# CITY OF ALBUQUERQUE

**RE: All-Rite Construction Warehouse  
Grading and Drainage Plan  
Stamp Date: 12/19/17  
Hydrology File: K09D042**

**RE: All-Rite Construction Warehouse  
Grading and Drainage Plan Stamp  
Date: 12/09/17  
Hydrology File: K09D042**

C-101

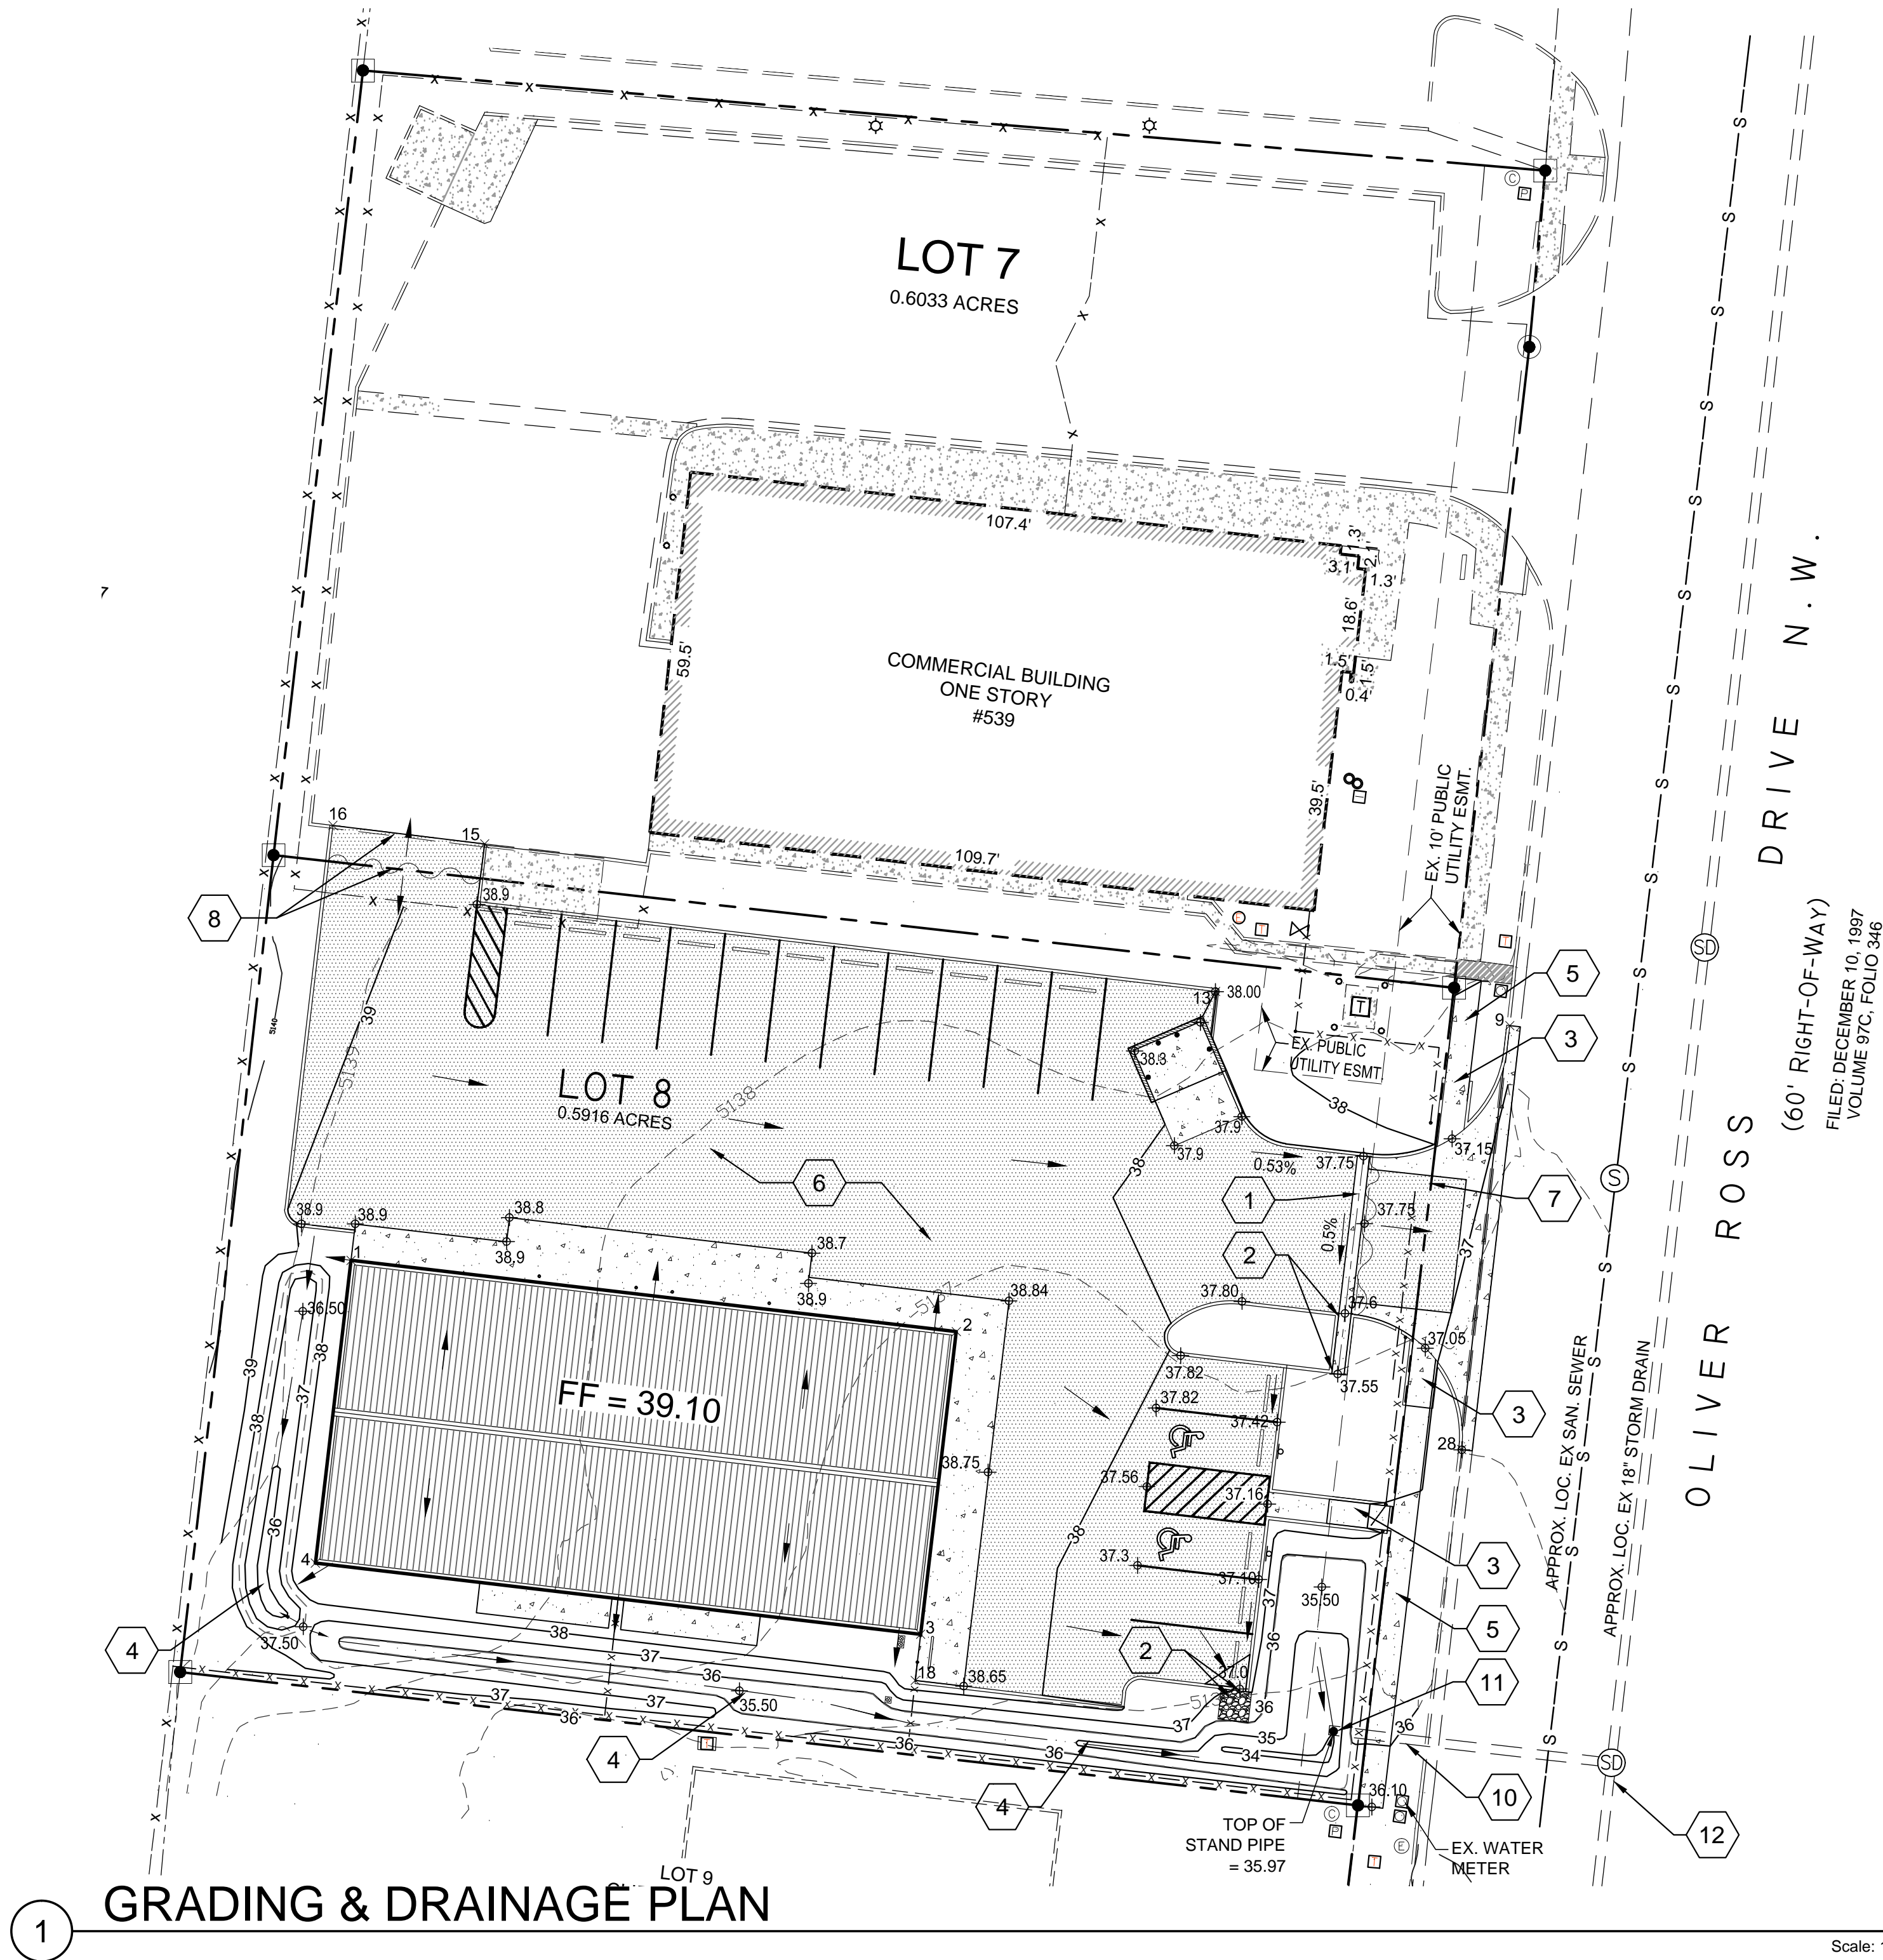
1. Effective date has been added to the FIRM information. Refer to sheet C-101 dated 12/19/17.
2. Water block per COA Paving Detail No. 2426 at the driveway has been updated on grading plan. Refer to sheet C-101 dated 12/19/17.
3. First flush drainage has been routed through the first flush ponding area and will be discharged into existing storm drainage system in Oliver Ross Drive. Refer to sheet C-101.
4. Offsite discharge has been limited to 0.48cfs per master drainage plan. Refer to keyed note #11 on sheet C-101 dated 12/19/17.
5. Offsite discharge has been limited to 0.48cfs per master drainage plan and will discharge into the existing 18" CMP stub out per master plan. Refer to keyed note #11 on sheet C-101 dated 12/19/17.
